Online Comment

Application H16-0251-25
Location Monks House Bourne Road Spalding PE11 3LH
Proposal Conversion of loft to habitable space, internal alterations, addition of dormer window to west elevation, re-roof & reinstatement of historic windows

Name Spalding & District Civic Society
Address 36 Park Avenue Spalding Lincs PE11 1QX

Date Submitted 16-05-25
For/Against Objections

02 | PROPOSED LOFT PLAN

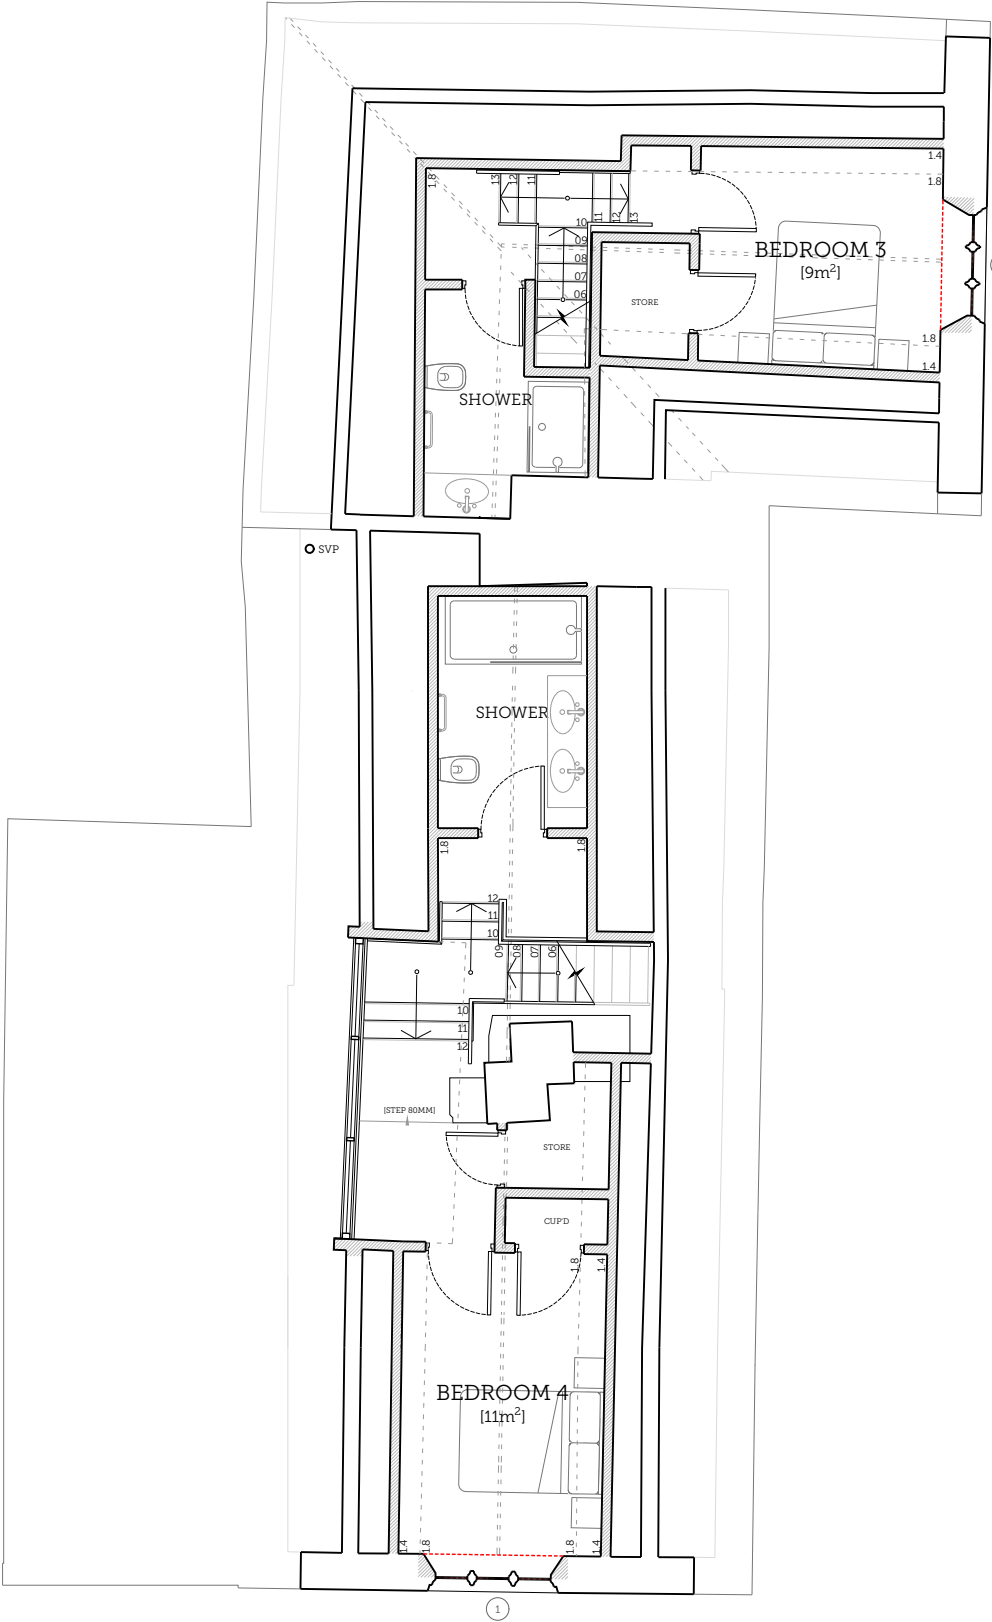
The proposed dormer window seems to serve no other purpose than to provide light onto the landing area. Could alternatives be considered such as a heritage conservation window or sun tunnel windows that would reduce the visual impact of the proposed loft conversion?

Paragraph 5.6 of the Heritage Impact Assessment is headed ALTERATION 4: NEW DORMER WINDOW IN EAST-FACING ROOF SLOPE. However, the text and proposed elevation images suggest that the proposed dormer window is on the west facing slope of the building. We are concerned that the proposed dormer window is too large and would clearly be visible from both the North and South Facing elevations. As such we consider that it contravenes policy 29 of the South East Local Plan at A1. It is an alteration that does prejudice the architectural interest of the building. The proposal also contravenes paragraph 213 of the National Planning Policy Framework that requires justification for harm to the significance of a designated heritage asset from it's alteration to be exceptional. We do not consider that the justification for the proposed dormer window to be exceptional in this case.

The applicant has not indicated how the dormer window might be constructed and of what materials the dormer might be constructed. Without this information and for the reasons stated above, we cannot support the application as it stands, and ask that you note our objection to this application.
